Re: Planning Application 18/1121

Address: The Stables rear of King Street Whalley BB7 9SP

Description: Change of use to new restaurant on ground floor and new retail unit at first floor level. General refurbishment of existing building with new single storey extensions and structures to courtyard area and to rear elevation. New wall, gate and timber screens to front and side boundaries. Resubmission of application 3/2018/0530.

Simon Hardie
Highways Development Control
Lancashire County Council

Proposed Site Plan  
Scale 1:500

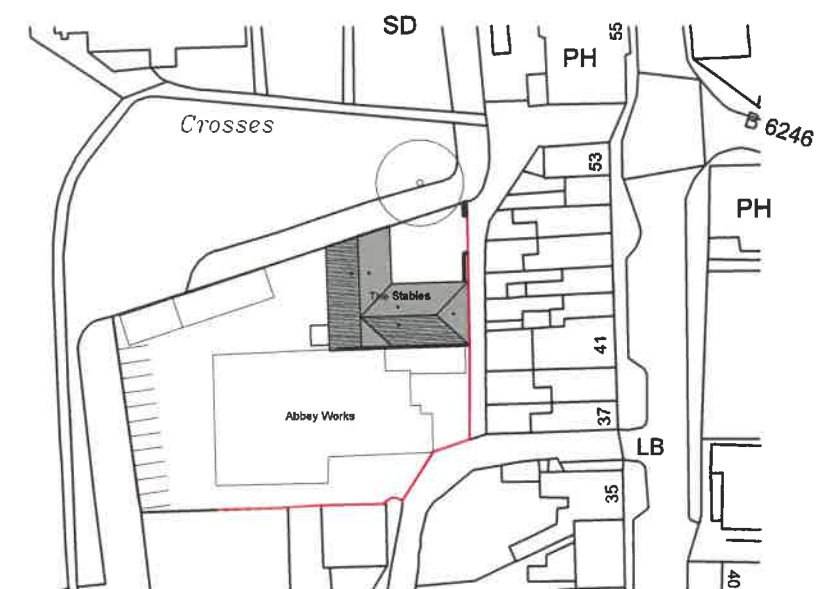
The access to the parking situated at the rear of the site is accessed via an un-adopted lane which not designated as highway and would not consider sufficiently wide enough to allow two cars to pass unhindered. The general site is shared with a number of other business where there is no segregation between the vehicle and pedestrian movements.

The plans provided show some parking areas that are purported to be for the sole use of restaurant staff and customers, however it has been noted from a site visit that these are currently designated for the use of two other premises adjacent to the restaurant. If these designated parking areas are reassigned then this will displace additional parking hazards which will need to be accommodated within the general area, potentially compromising the conditions imposed on other developments within the area.

It is noted from the previous submission that there is a concern regarding the lack of lighting to the car parking area. Additionally, an application (no 3-2012-0824) for an adjacent premises to provide a walk in taxi booking office has also been refused siting "highway safety" grounds.
